**SUBSIDENCE IMPACT ASSESSMENT  
– GUJARAT NRE NO. 1 MAJOR EXPANSION  
PROJECT  
Independent Peer Review**

**PART 3: Review of NRE Preferred Project Report –  
Subsidence Assessment**

**REPORT NO:** 1303/02.3

**DATE:** 17<sup>th</sup> November, 2013

Figure 2: Plan showing the design constraints (lease, geological, mining, and surface protection) as the basis for the PPR mine layout design

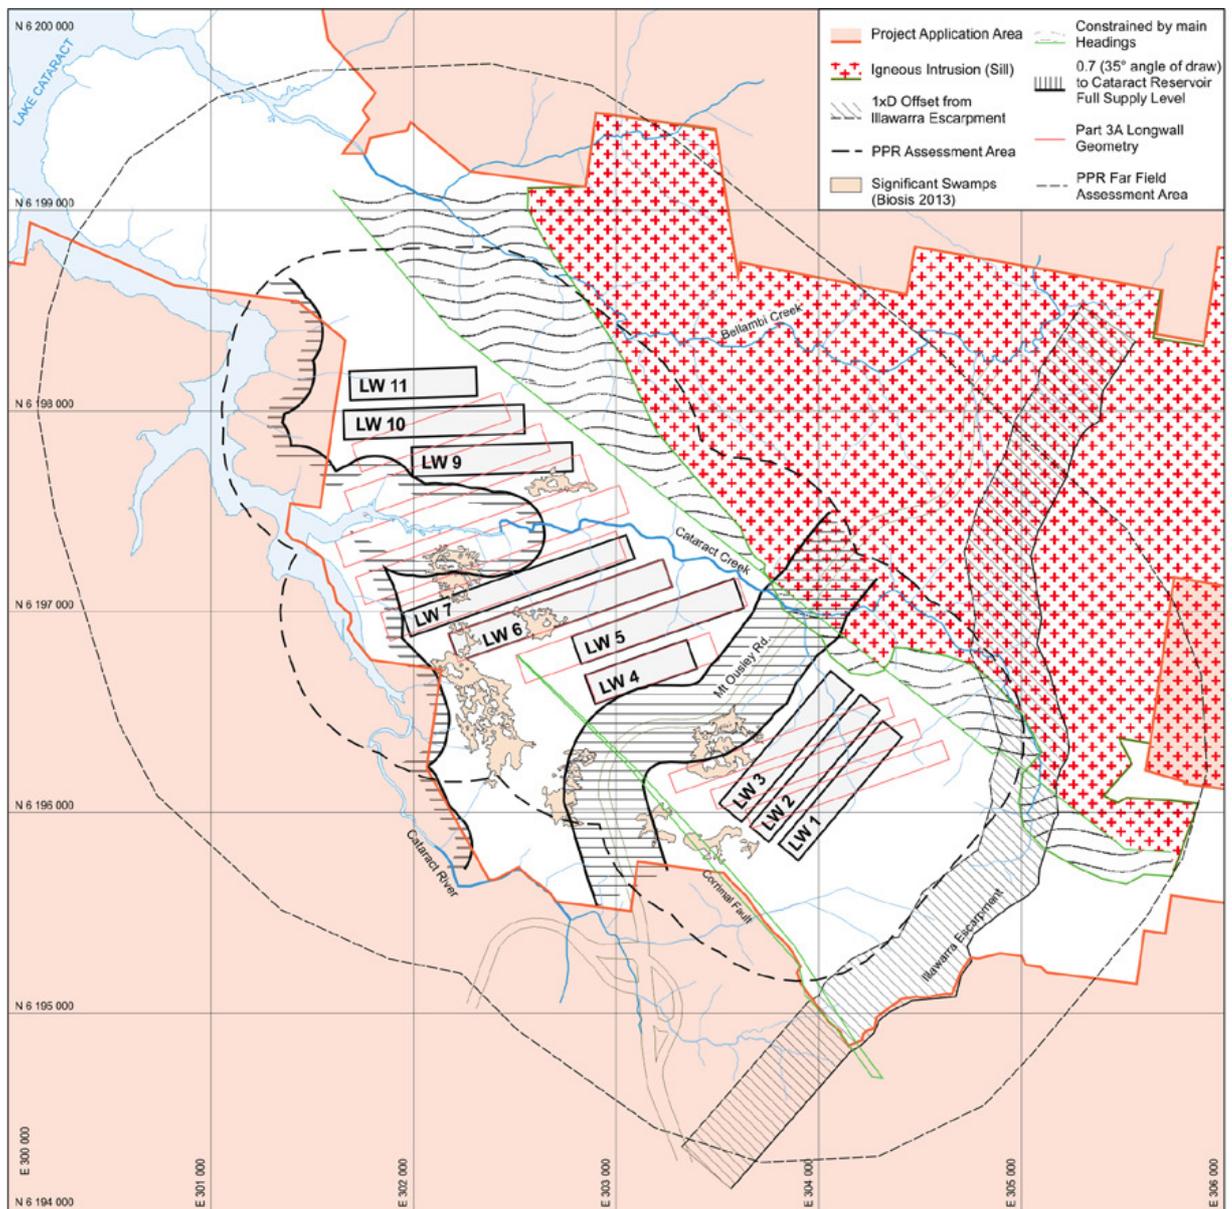
These constraints all seem reasonable and appropriate, however the constraint with respect to the significant upland swamps lacks any quantitative or measurable definition, in terms of how does this translate to a design constraint. Figure 2 is a copy of Figure 2 from the SCT report, showing both original and the revised PPR mine layouts, together with the various constraints identified above.
